10. **Project# 1007246**
08DRB-70382 MINOR - PRELIMINARY/
FINAL PLAT APPROVAL

DRB Comments

PROJECT # 1007452

RE: Lots 1-4, Block 38, Mesa Verde Addition

VICINITY MAP No. K-19

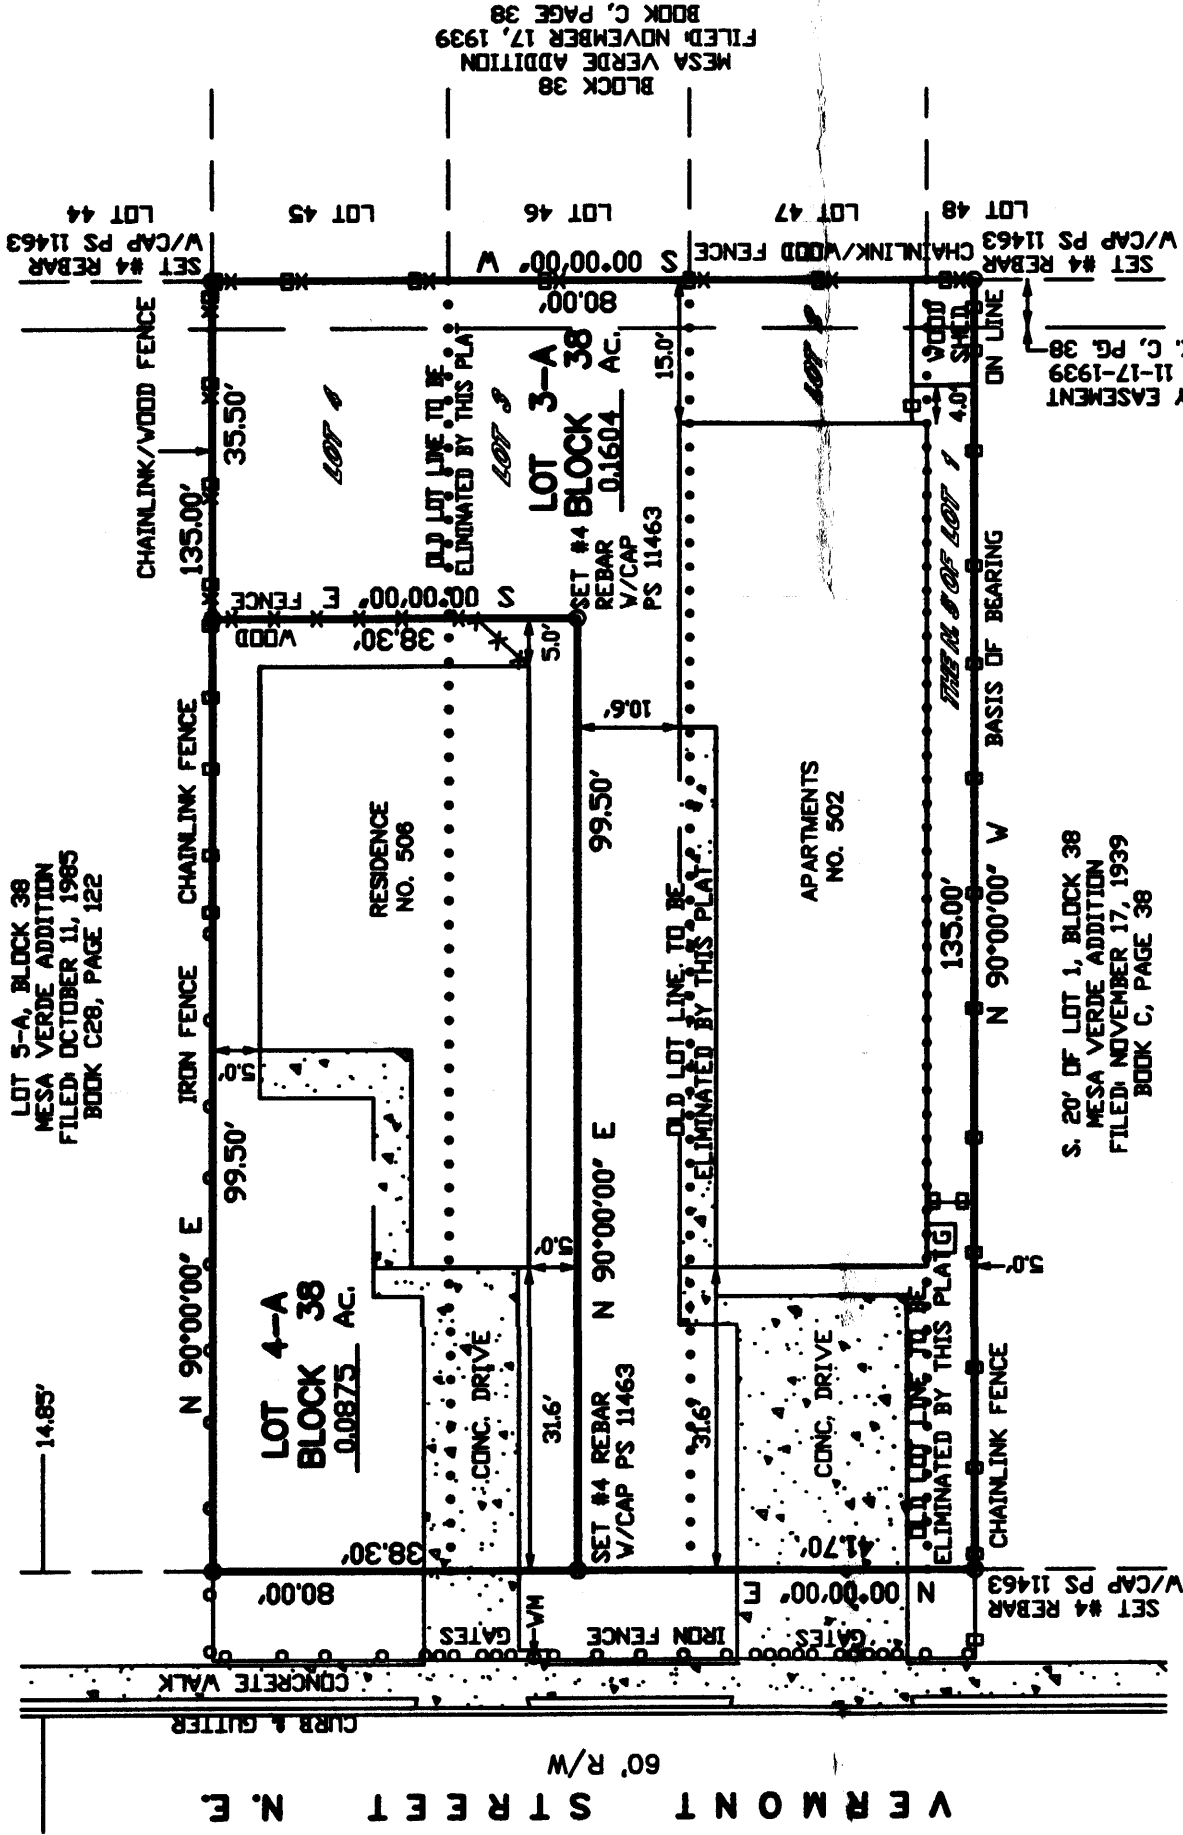
The Vicinity Map on the plat is incorrect (shows Block 27, not 38);
subject site is further north than shown.

Provide an exhibit showing the location of sidewalk and defining the distance from face of curb to the property line. Right of way dedication may be required.
The existing fence currently encroaches upon the City right of way. This must be remedied prior to any replat.

Provide a correct vicinity map with street names.
